Engineers Comments Regarding Surface Water Drainage

Application Reference:	AL/103/25/DOC	Reviewer Reference:	ADC/EXT4
Planning Officer:	Simon Davis	Date of Review:	04/12/2025
Site Name:	Land Adjacent to Woodgate Nurseries Lidsey Road Aldingbourne		
Application Description:	Approval of details reserved by condition imposed under AL/129/21/OUT in relation to conditions 16-Surface Water Drainage Scheme, 17-discharge flows to watercourses and 18-maintenance and management of surface water drainage.		
Assessment Number:	1 of 2

Application Reference: AL/103/25/DOC Site Name: Land Adjacent to Woodgate Nurseries Lidsey Road Aldingbourne	Initial Issue Date: 04/12/2025 Issue Date: Reviewer Reference: ADC/EXT4
---	--

Existing ditch through the site with proposed re-grading levels and culverts
Scale 1:500H / 1:100V @ A1

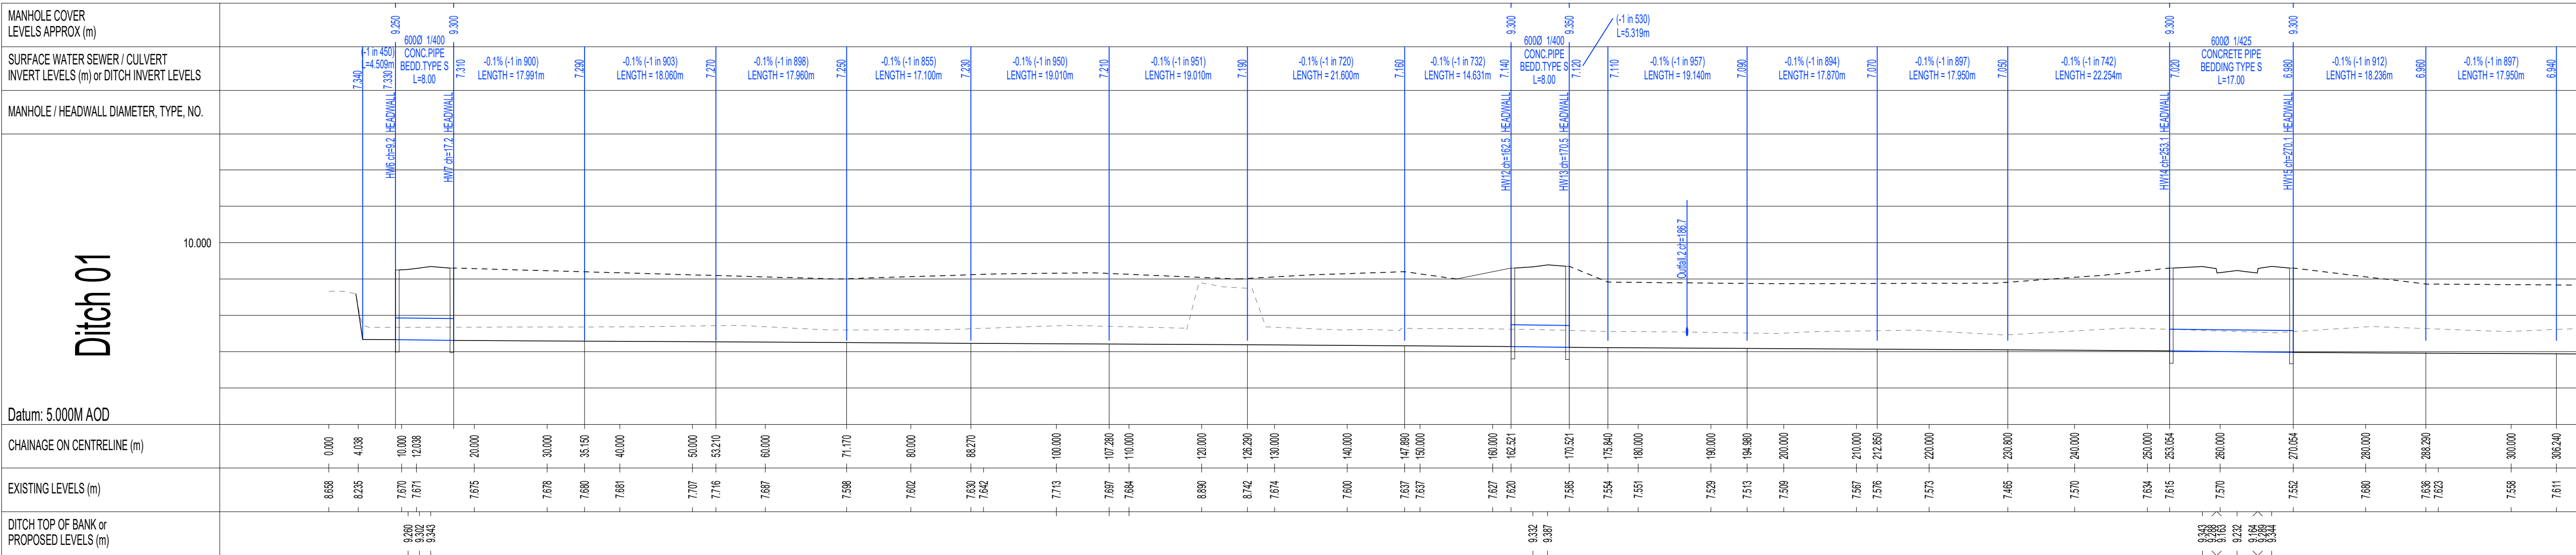
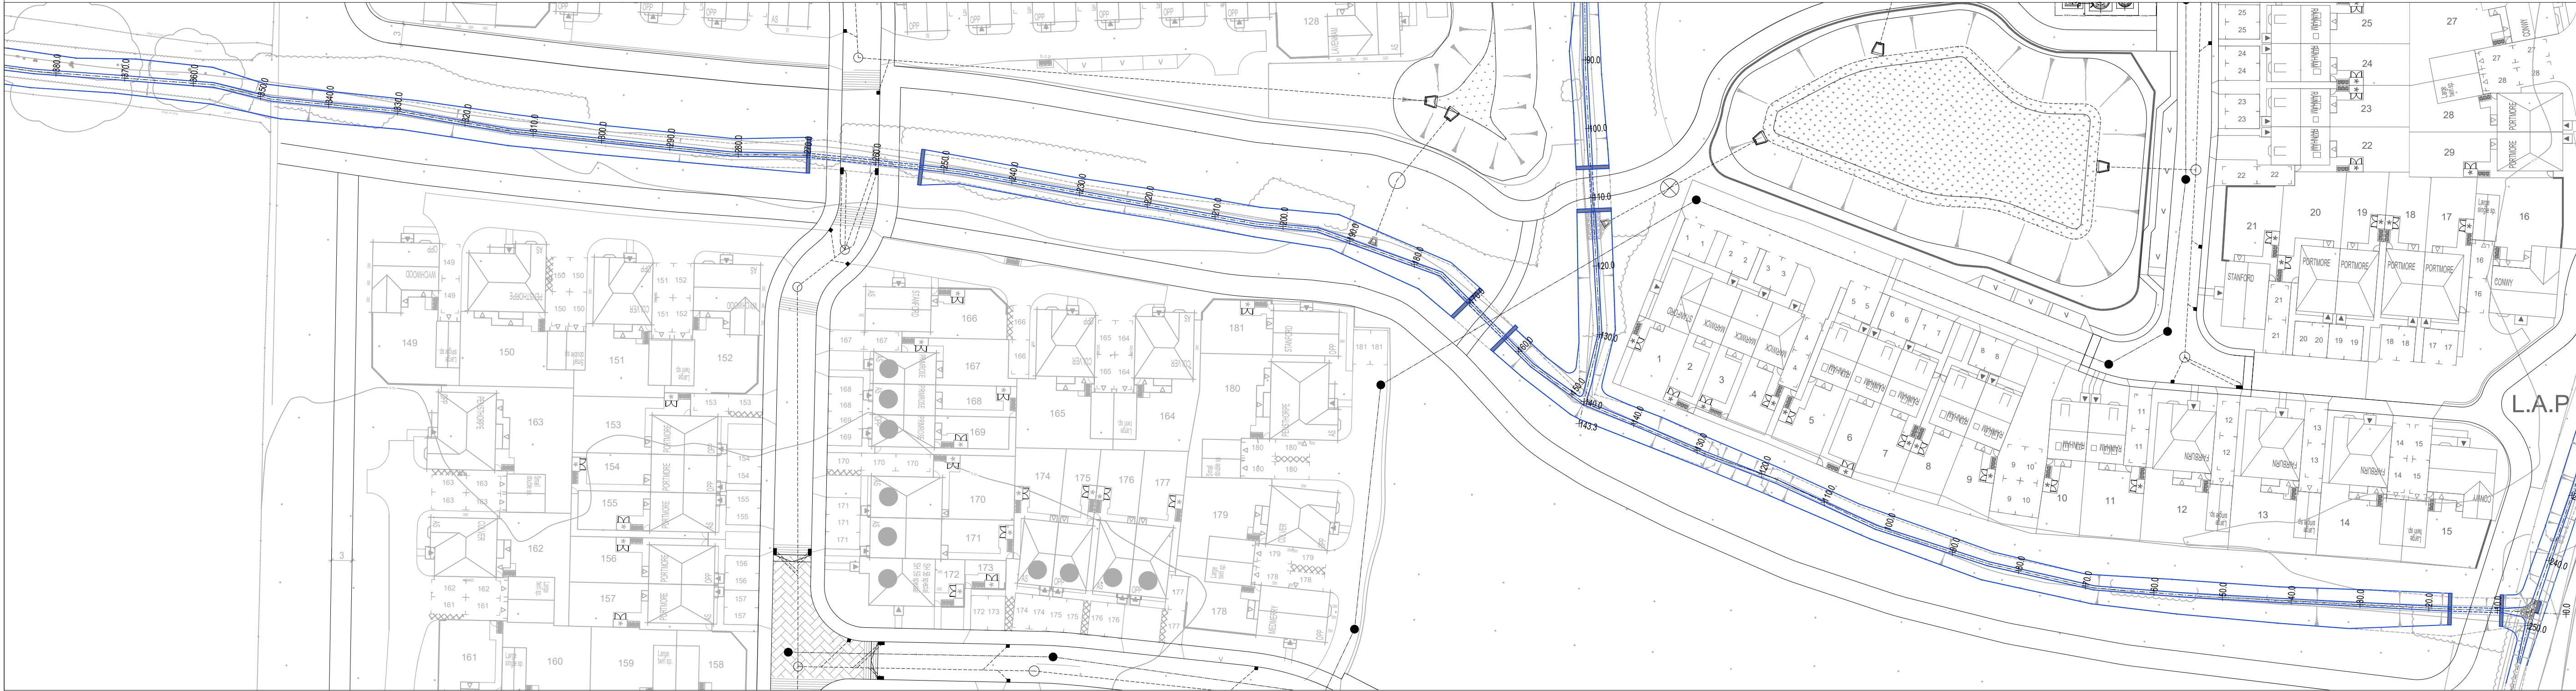
Comment Number					
1.	Please note that the proposals for the construction of the new headwall outfalls and culverting of the existing watercourses will require Ordinary Watercourse consents. Please submit the consent to demonstrate no conflict between approved plans.	Please find enclosed Ordinary Watercourse consent for drainage works on the watercourses, that consist construction of culvers / headwalls, regrading of existing ditches. No consent is required for outfall to watercourse as the outfall profile doesn't encroach into ditch profile.	The drainage layout clearly shows that the headwall encroaches into watercourse, including works to outfall base and erosion control measures. The long section provided noted regrading to the ditch bed level as well. Please provide construction details of outfall to ditch as well as OWC

2.	Please provide evidence of positive dialogue in relation to the proposed culvert of the watercourse, in terms of capacity assessments and confirmation of ecological and tree protection impacts or mitigation. Some of the proposed headwalls appear	The ordinary watercourse consent on the culvert has been received on 3rd September 2025. No objection has been raised by the WSCC Flood Risk Management Engineer. With regards to tree protection and mitigation	Provide details of design and drawings which have been approved by this OWC
